Subject: Written Representation Submission for
Deadline 1 – East Pye Solar (EN0110014)

- Project Name: East Pye Solar
- Project Reference: EN0110014
- Submission Content: Full Written
Representation containing an integrated
Executive Summary, Methodological
Disclosure, primary evidence exhibits, and
specific cross-examination questions
regarding parameter contradictions, battery
storage queue status limitations, and

SECTION 1: SITE ONE (THE CENTRAL TRANSMISSION & BESS COMPLEX)

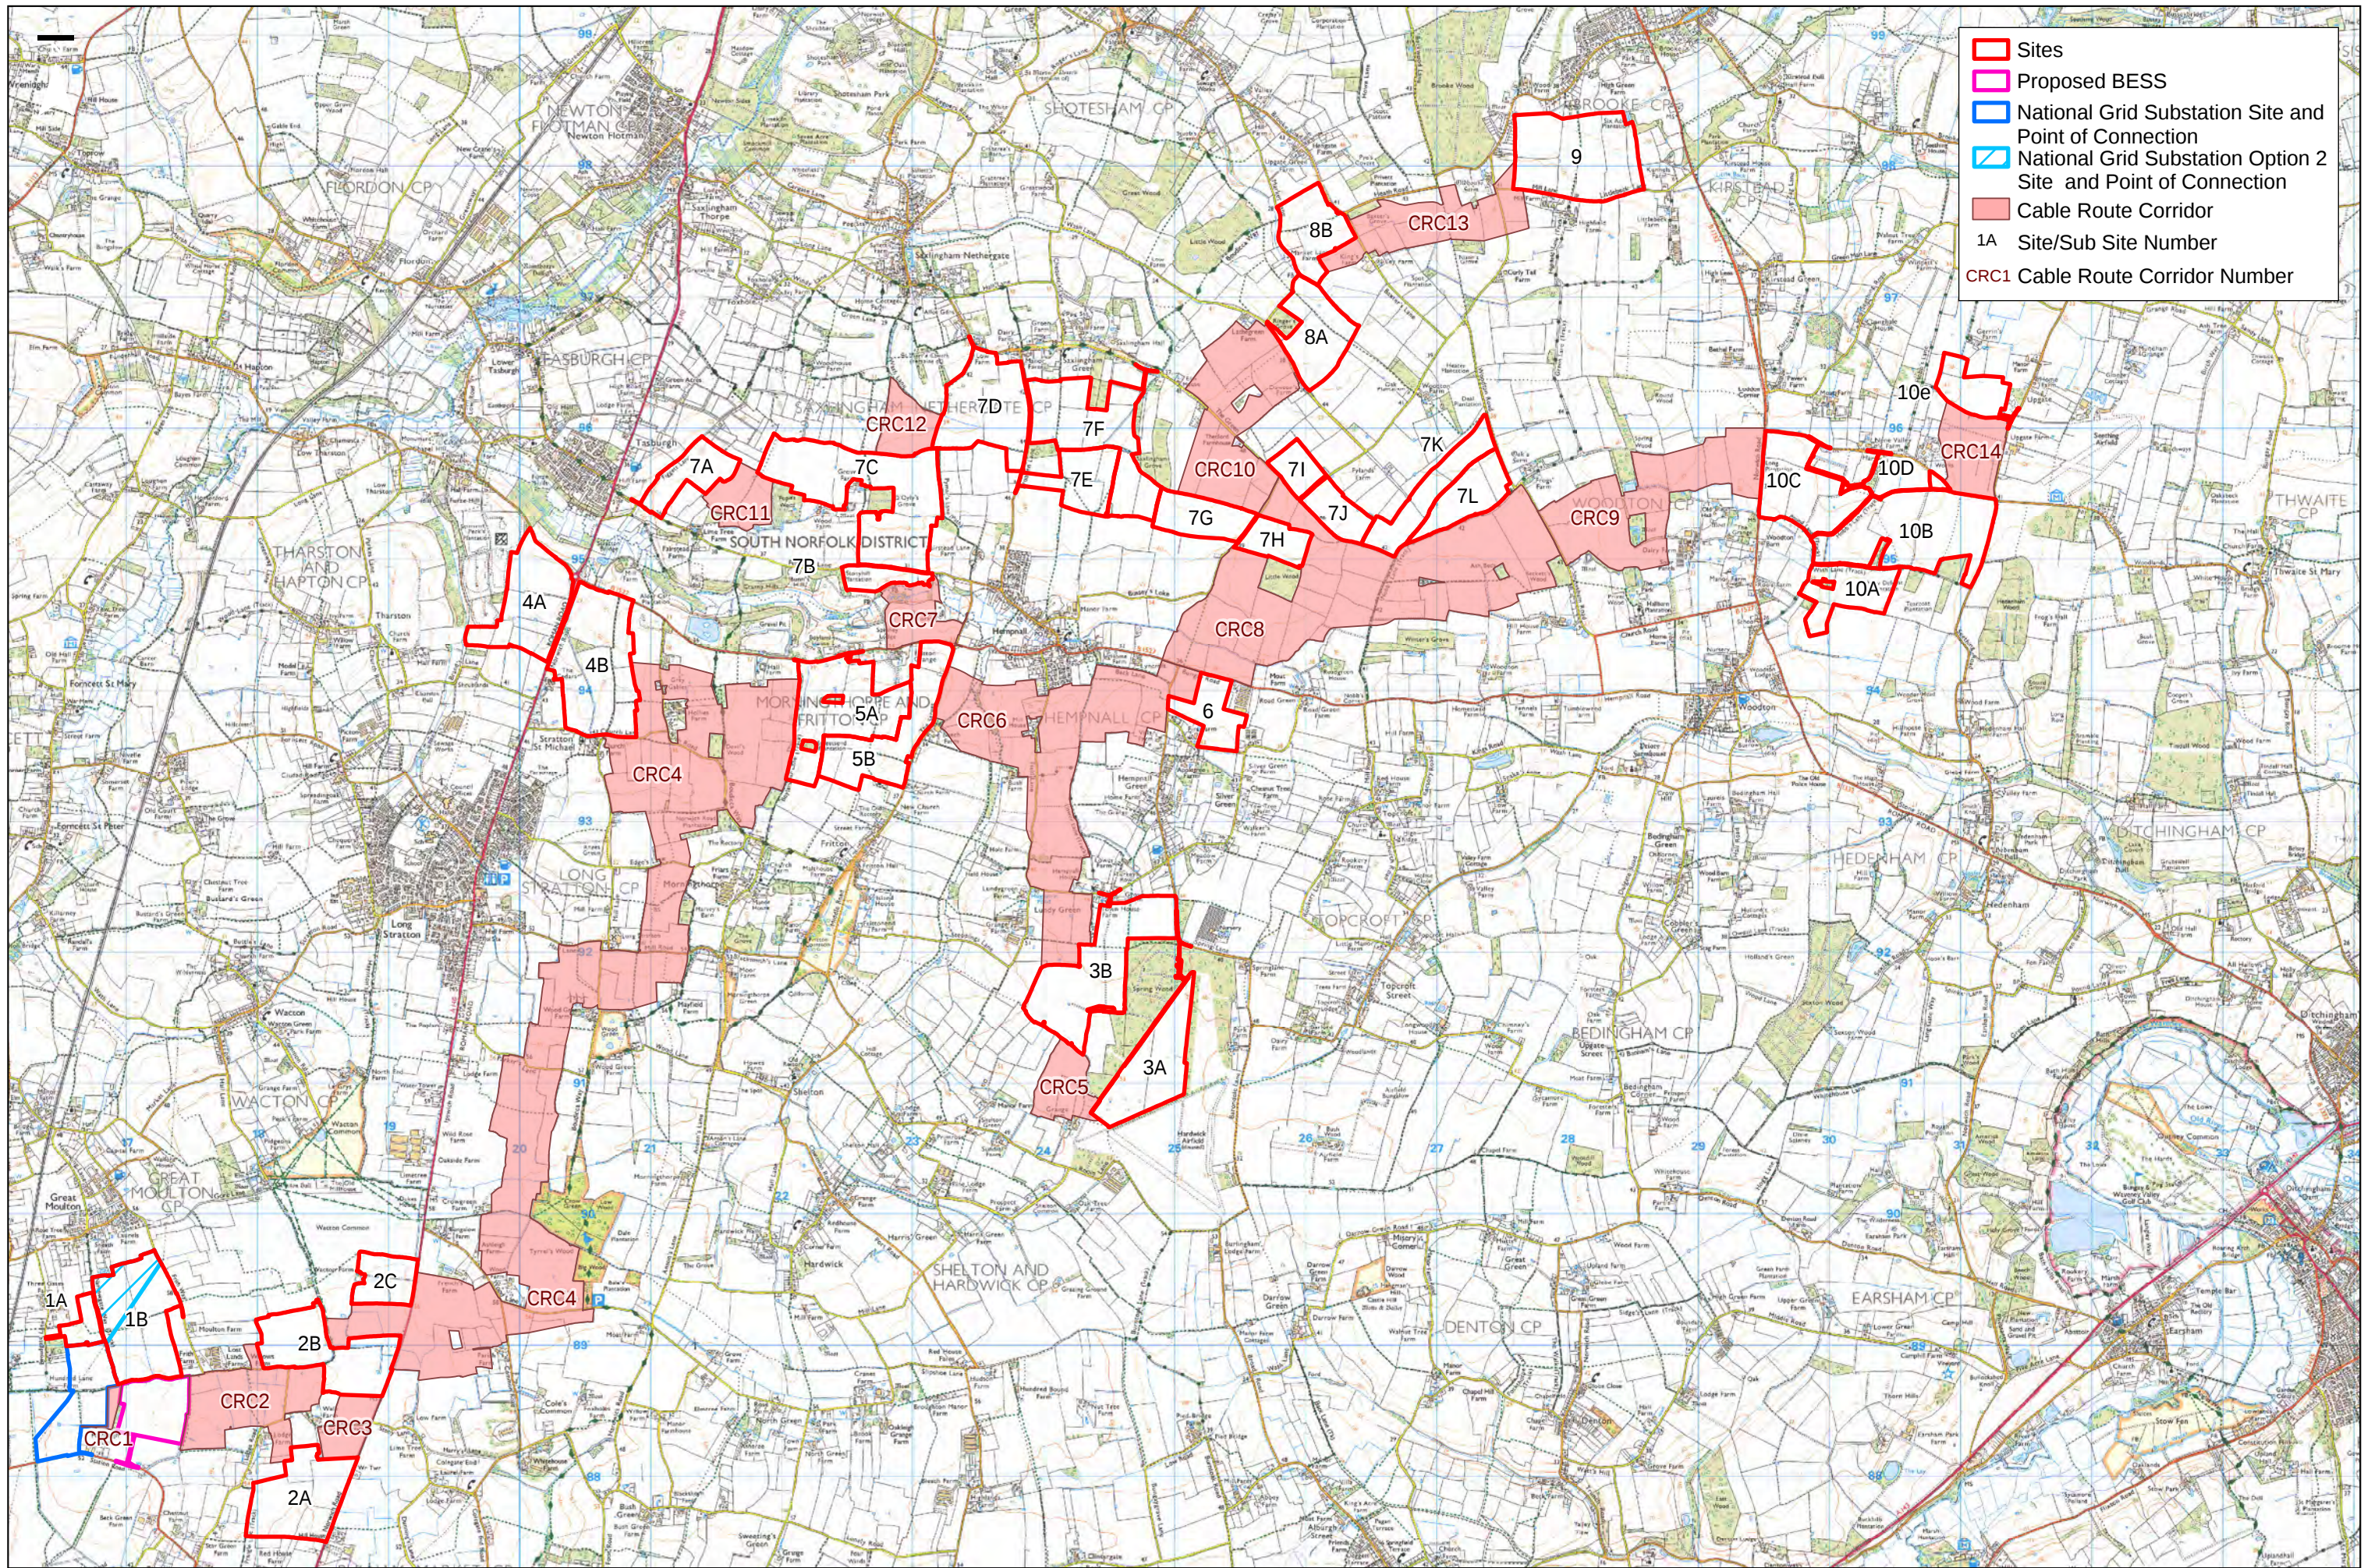
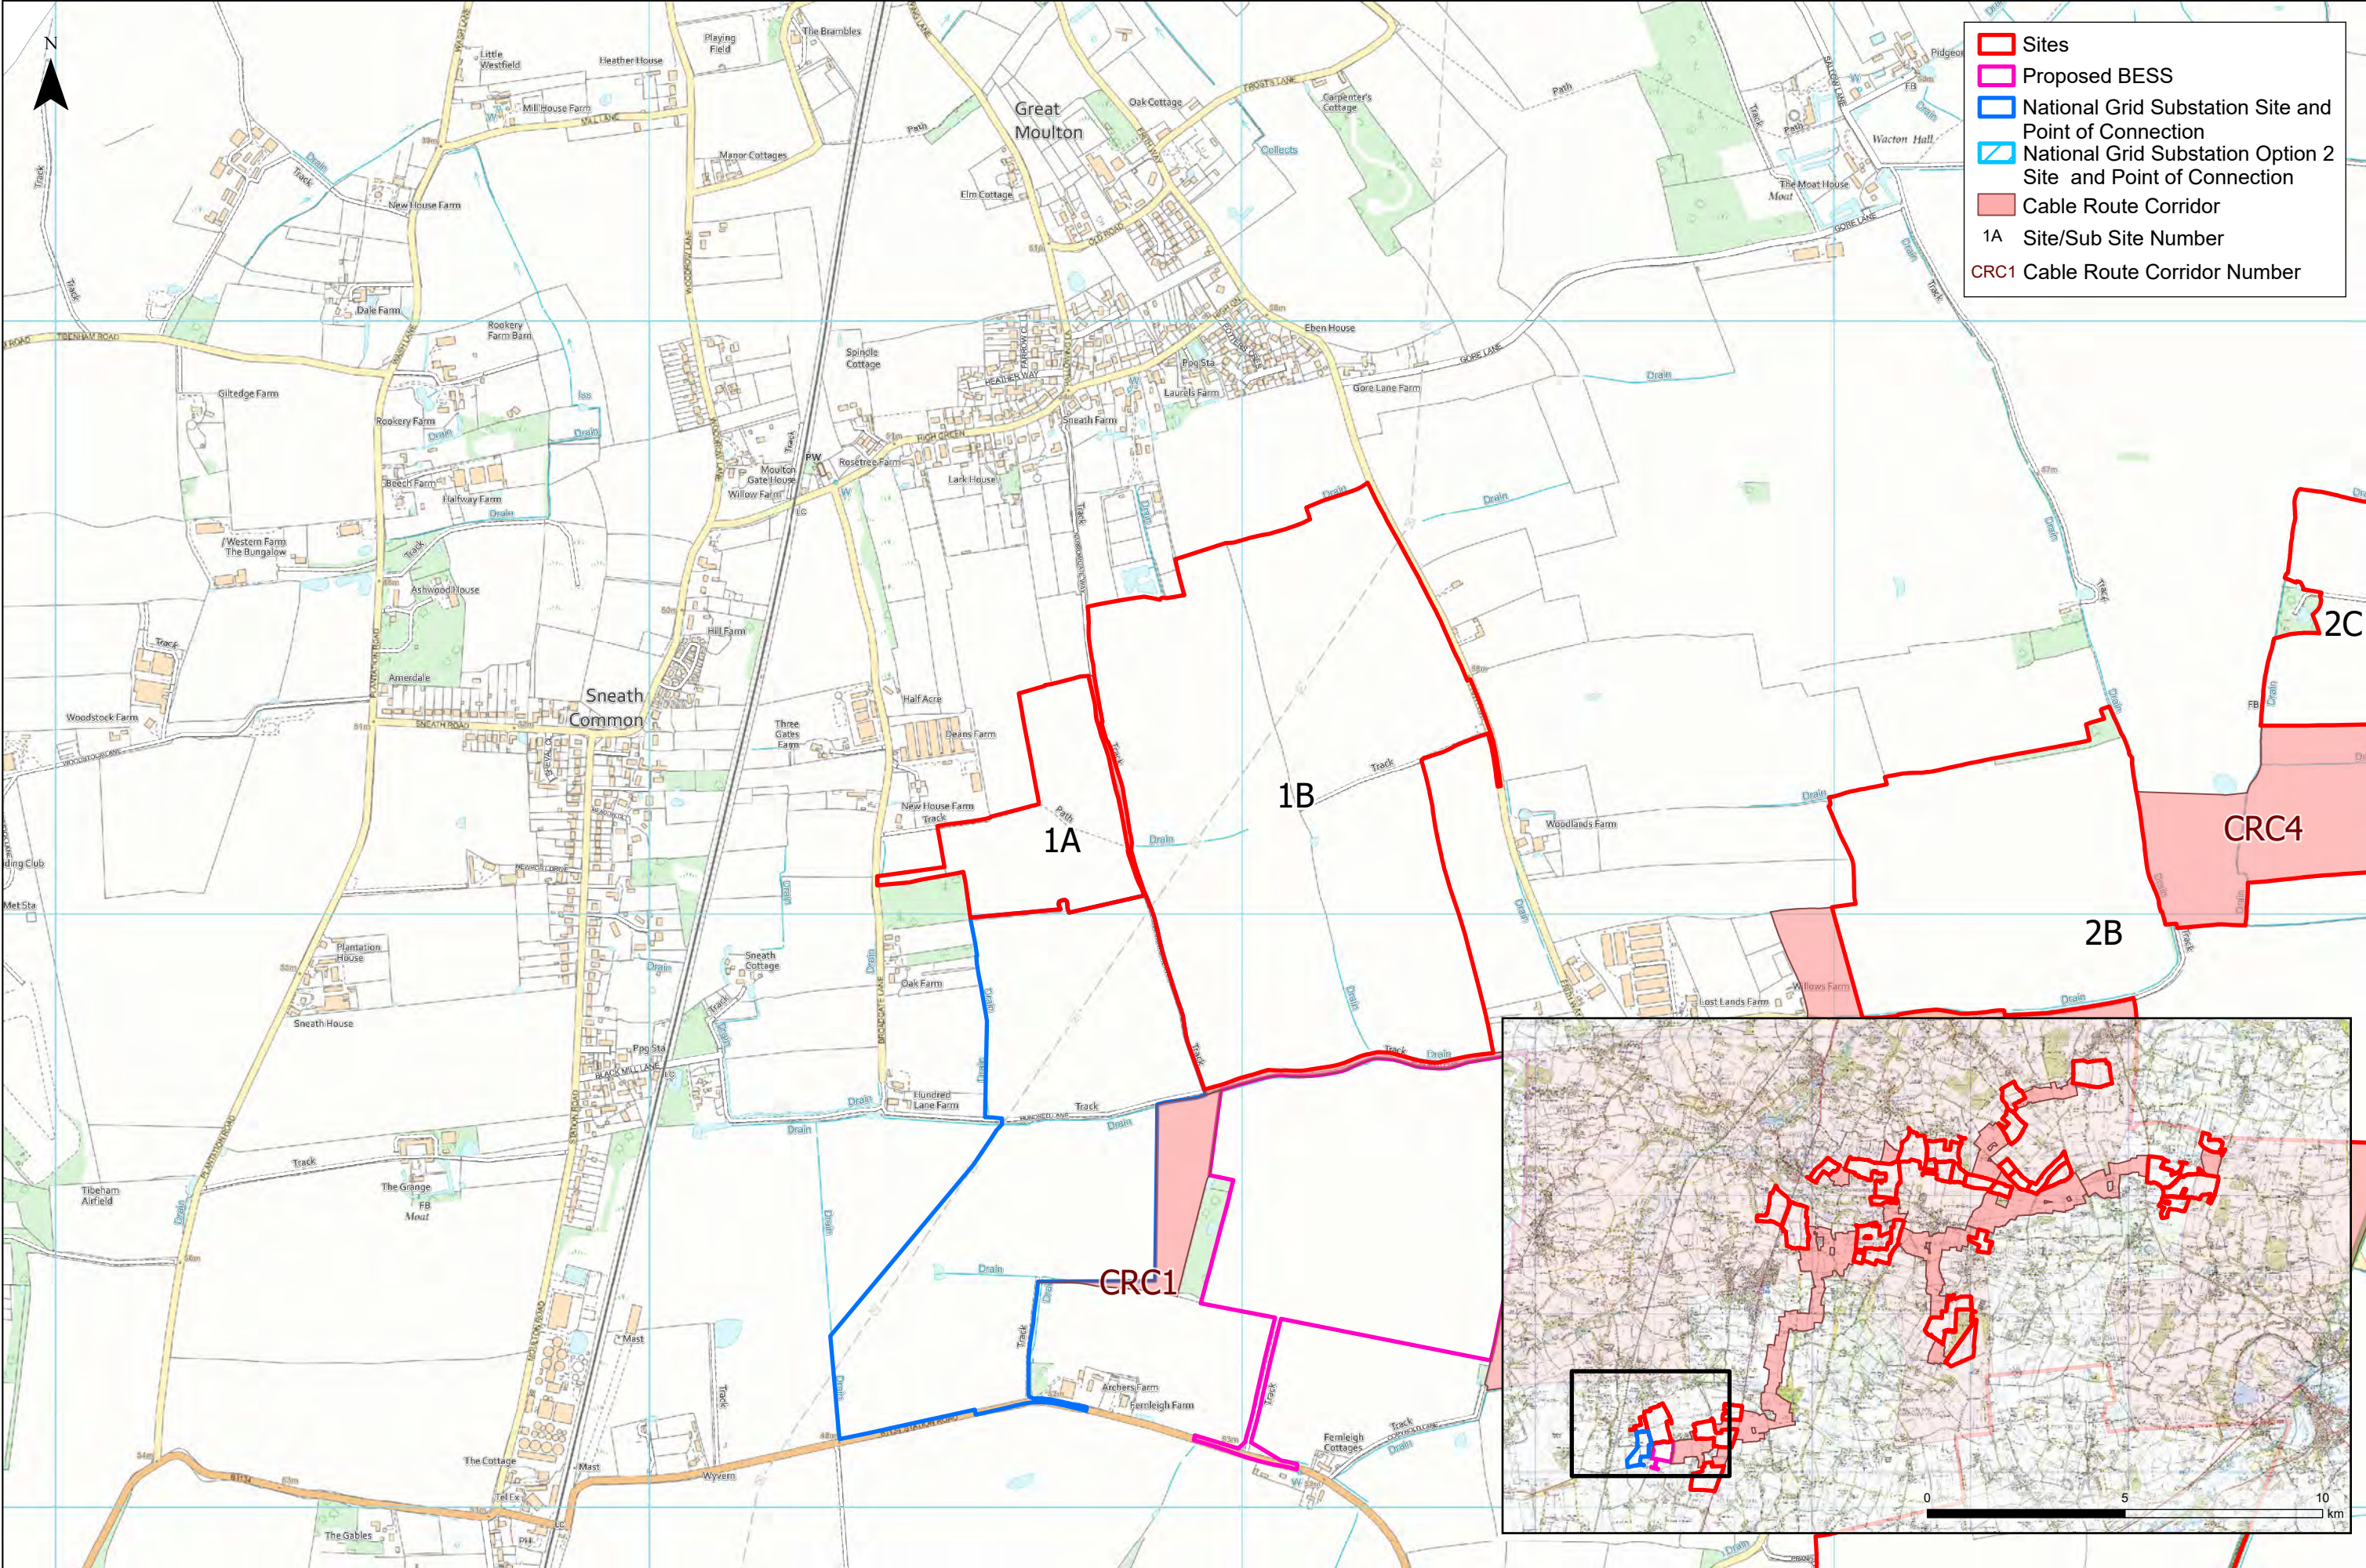
A major contradiction exists between the submitted graphic plans, the public consultation promises, and the accompanying written text. The Applicant's framework explicitly stated that the development would be limited to a maximum parameters of three 132 kV substations and three 400 kV substations

across the entire project. However, the site plans demarcate three distinct 400 kV voltage class substations within the concentrated Site One compound alone, while a fourth 400 kV substation footprint is explicitly drawn on the master maps at Site 7 near Saxlingham Green. Component heights track up to a maximum parameter of 15 metres. Furthermore, specific hardware models remain uncommitted until post-consent procurement, meaning equipment options produce divergent acoustic signatures near residential boundaries. The Applicant's environmental noise statement relies on generalized acoustic models tailored exclusively to a neurotypical baseline, omitting any technical assessment for the neurodivergent baseline of the host community. For individuals with neurodivergent profiles or sensory processing differences, un-filterable low-frequency industrial noise represents an

- Question to the Applicant 3: "The Applicant's consultation literature explicitly stated that the development parameters would be structurally capped at a maximum of three 400 kV substations. Given that the submitted master layout maps clearly demarcate three 400 kV substations within the concentrated Site One compound alone, and a fourth 400 kV substation footprint drawn at Site 7 near Saxlingham Green, will

own maximum promised infrastructure caps on the plans, and clarify exactly how many individual 400 kV substations are to be constructed under this DCO?"
